From: Harry Chalk
Sent: 30 June 2022 12:33:23
To: Harry Chalk
Cc:
Subject: FW: Elm Farm The Street Rustington
Attachments: Access from bedroom 20220505_144548.jpg

From: PETER SHAW <brycesonshaw@btinternet.com>
Sent: 30 June 2022 11:54
To: Harry Chalk <Harry.Chalk@arun.gov.uk>
Cc: Martyn White <Martyn.White@arun.gov.uk>
Subject: Elm Farm The Street Rustington

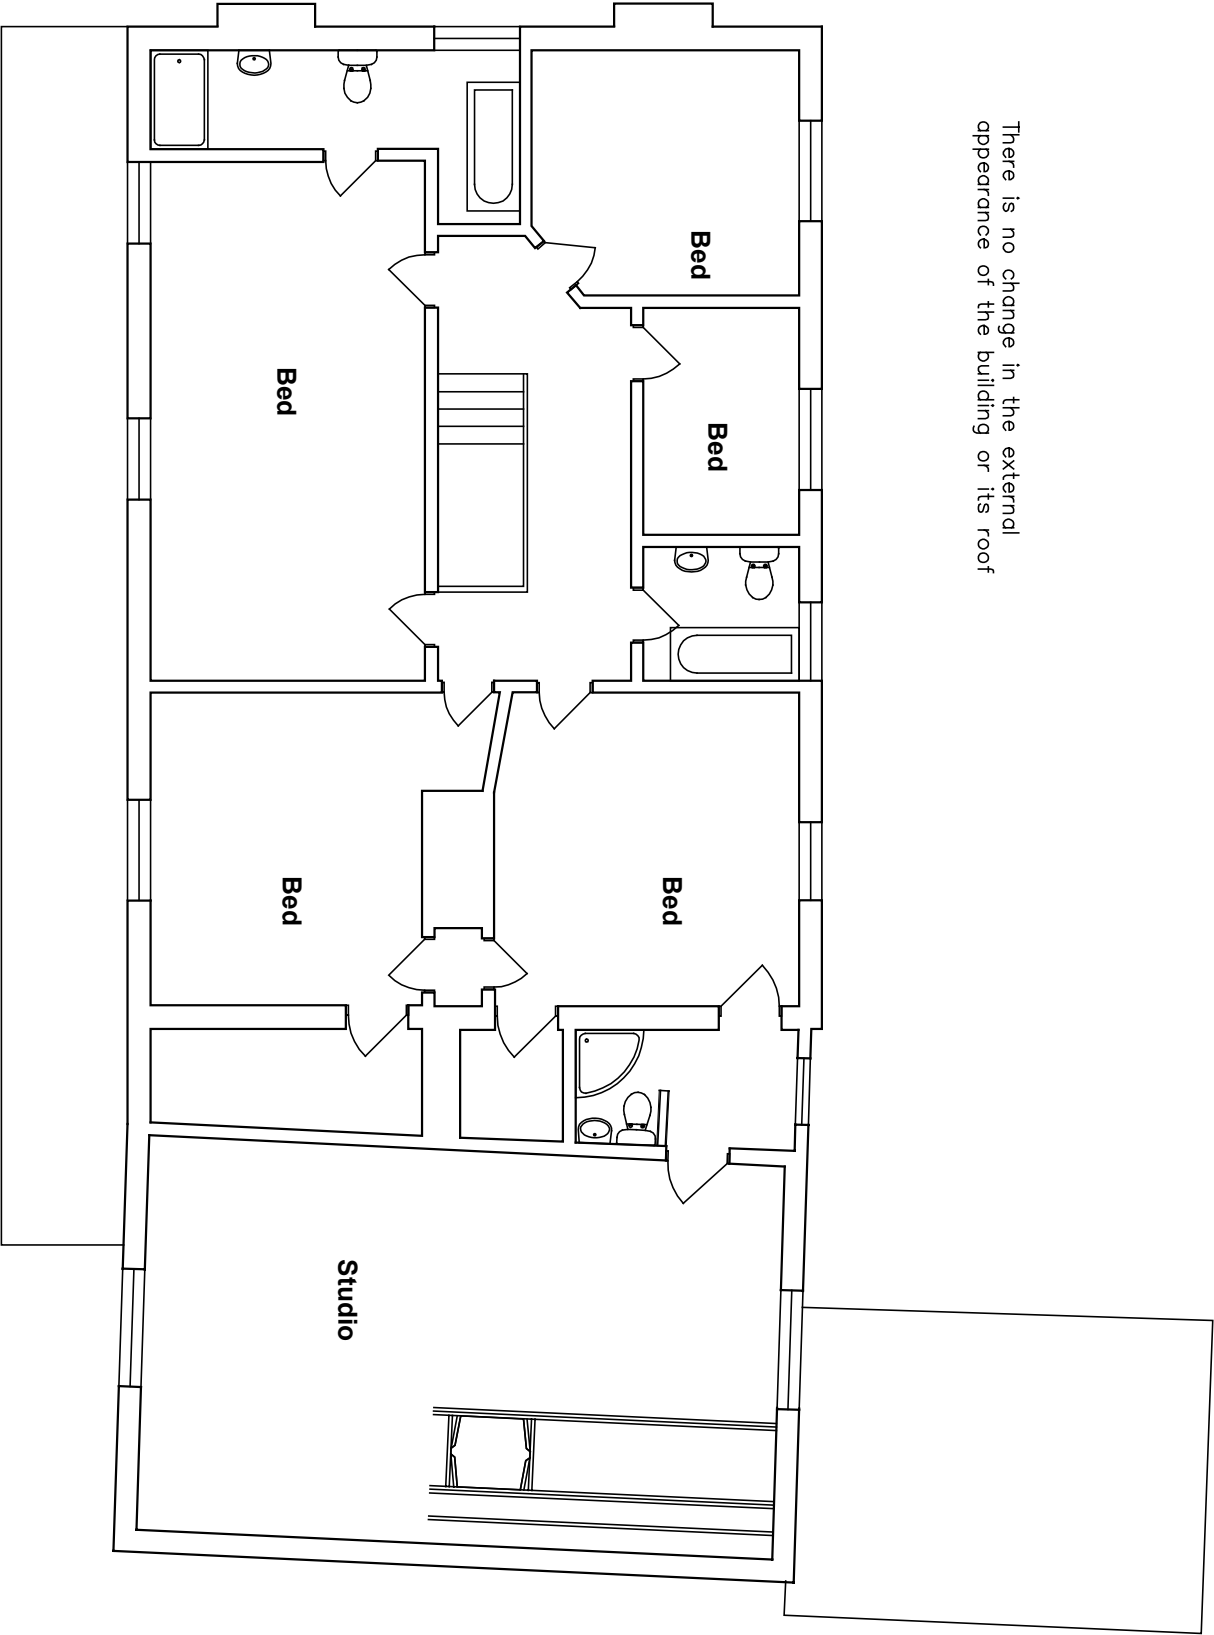
As discussed see attached photos of the first floor opening into the annex. This opening pre-existed because when exposed to repair a rotten lintel the old opening had been blocked up with breeze block.

Please add this opening to the listed application.
